# GOVERNMENT ARCHITECT NEW SOUTH WALES

**PROJECT:** Pymble Ladies College  
**RE:** State Design Review Panel – 16<sup>th</sup> March 22. Third Review

Thank you for the opportunity to review the above project a third time. Please find below a summary of advice and recommendations arising from the design review session held on 16<sup>th</sup> March 2022.

Visual Privacy of adjoining context

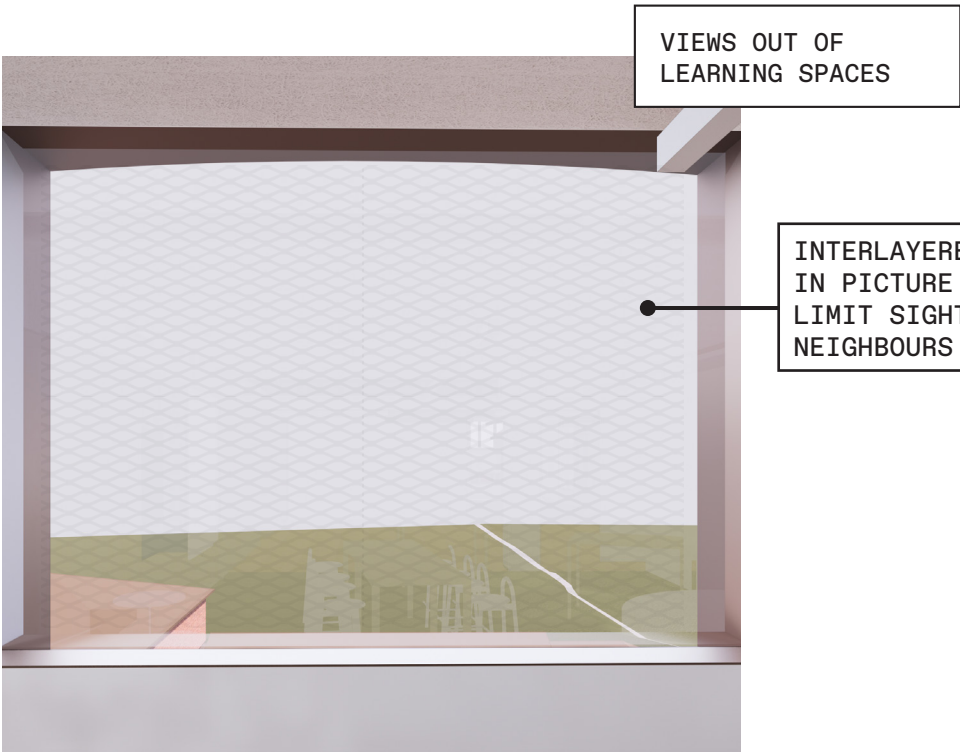
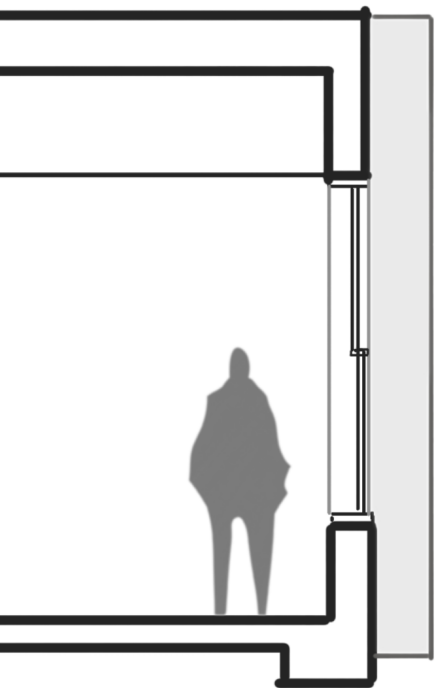
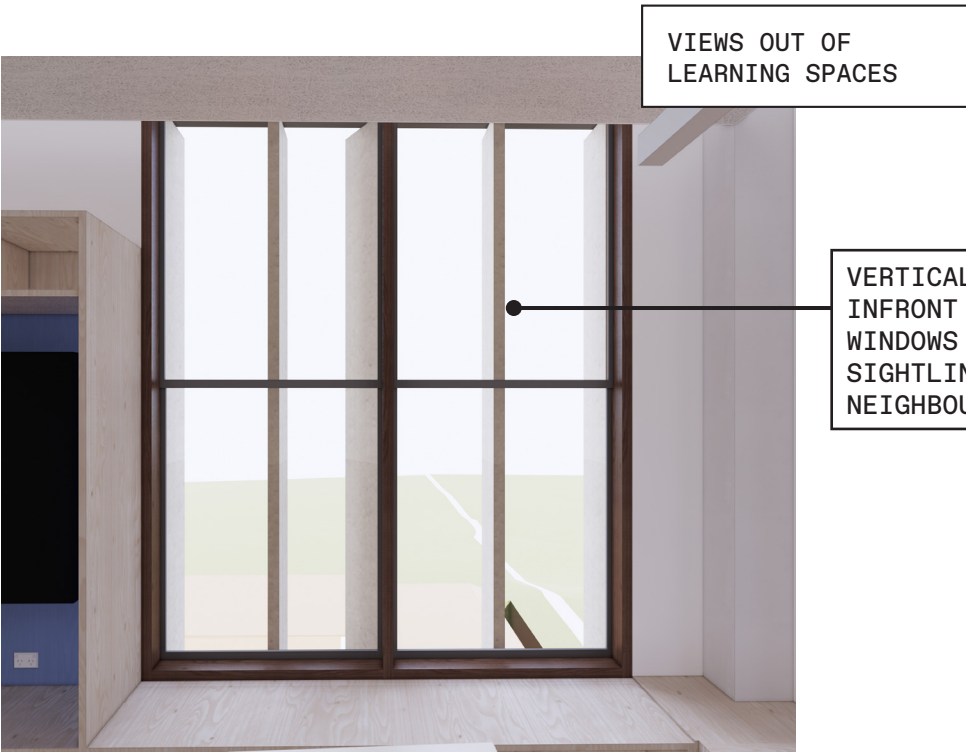
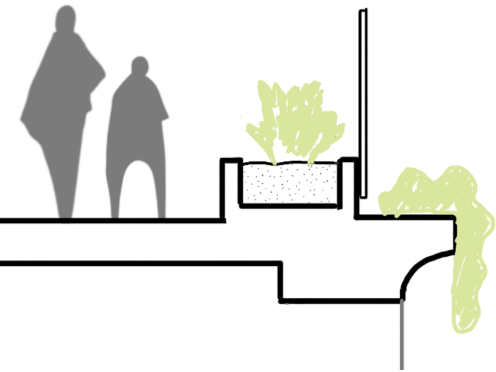
5. Reinforce the formal landscape approach on the north-west side of the building and the 'wild edge' along the south-eastern site boundary through the planting palette, species and hardscape materials to amplify the contrast between these landscape characters.
6. Develop the understory planting along the south-eastern edge to provide biodiversity and additional noise mitigation and visual privacy for the adjoining residential dwellings along Pymble Avenue.
